Address: Thornfield Bierley Marsh Bradford BD46PL

Application number: 2024/92849	
What is the application for?:	Change of use of land to domestic garden and erection of detached garage to side
Address of the site or building:	Cross Gables, Bierley Marsh, East Bierley, BD4 6PL
Postcode:	BD4 6PL

Type of comment: An objection	
Do you wish your comments to be published on the website anonymously?	No
Key objection points. Building Line Issues: The proposed development breaches the established building line for properties fronting Bierley Marsh, and the proposed structure would negatively impact the street character and spatial patterns. Scale and Massing: The two-story height of the proposed garage appears overbearing. The proposed materials, size, and bulk seem inappropriate compared to surrounding properties. Impact on Conservation Area: The location of such a large two-story structure, positioned in front of the existing building line and near the conservation area boundary, would visually dominate views from the conservation area. Previous buildings on the land/adjacent land were single-story sheds and greenhouses, which were much less obtrusive. Policy Conflicts: The proposed dom

site plan as proposed scale 1 : 200 @ A3

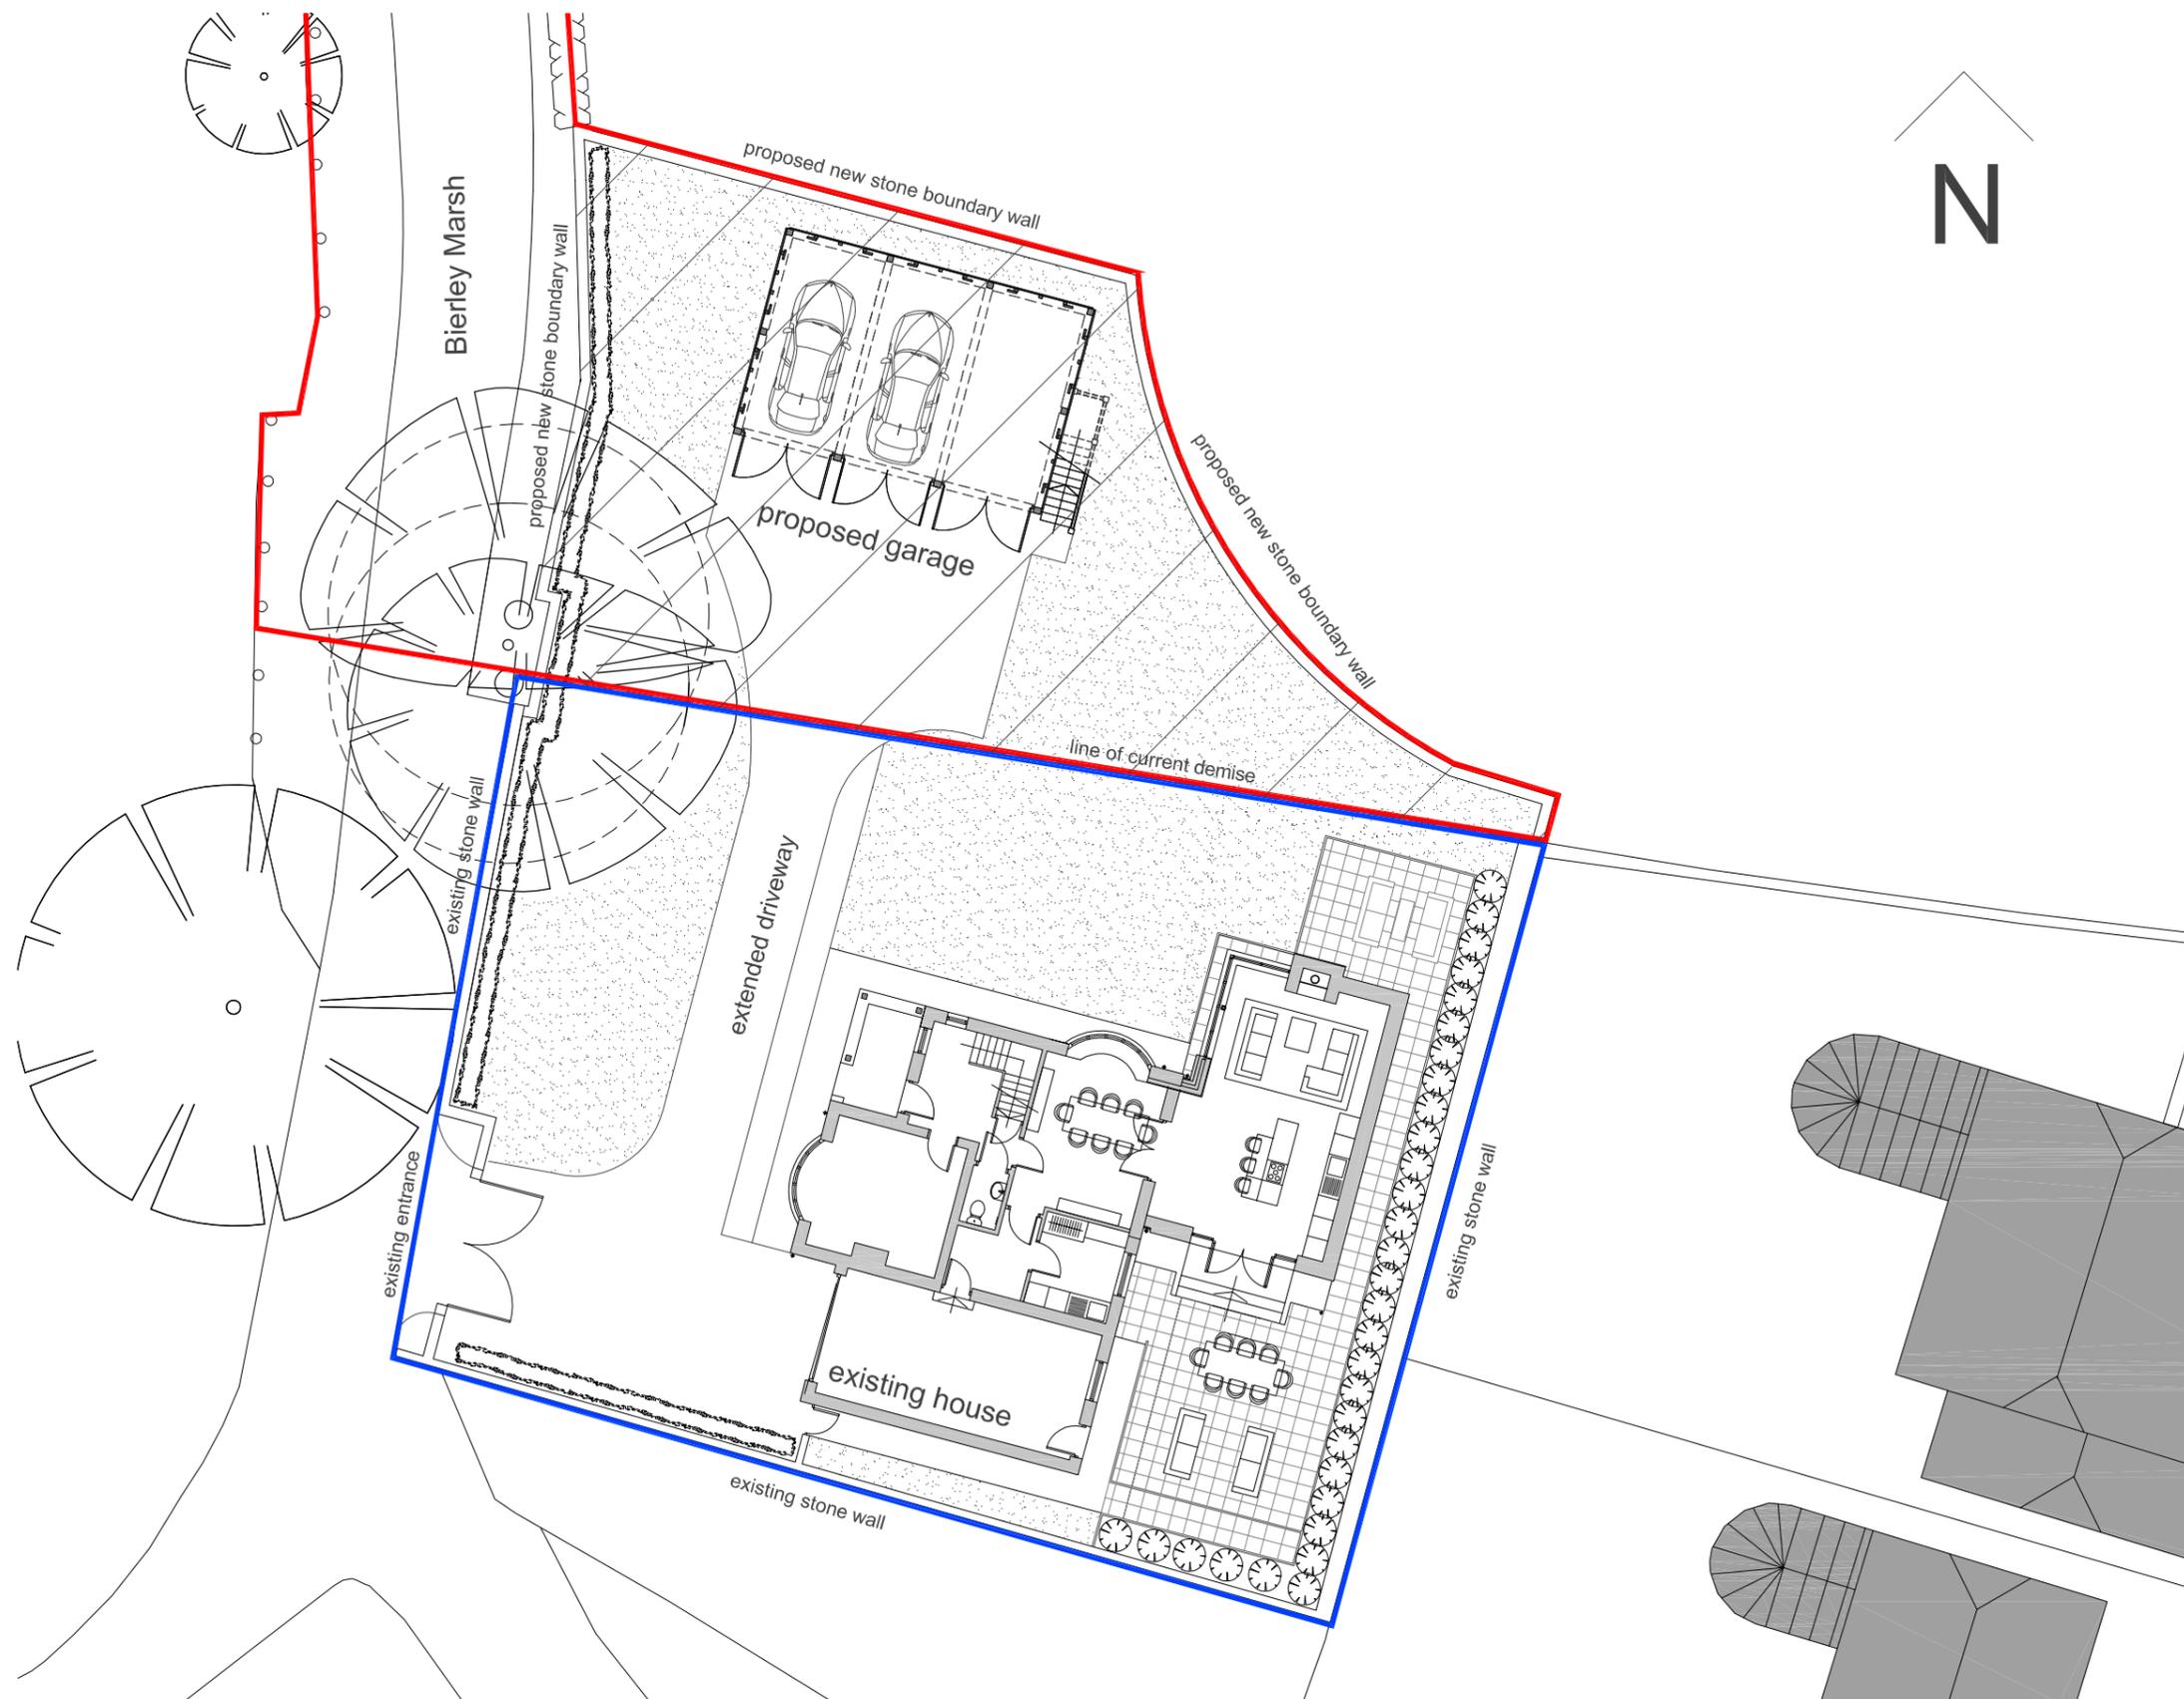
The plans submitted, with this application, show incorrectly, as a blue line boundary, land the applicant owns. The redline boundary shown is also partly over common land. It is noted driving over common and parking (unless 15yds within the public highway is illegal). It is unclear if the applicant has necessary associated approvals required, under the Commons Act 2006, to allow any works affecting common land.

The applicant should be asked to correct incorrect boundaries shown on plans.
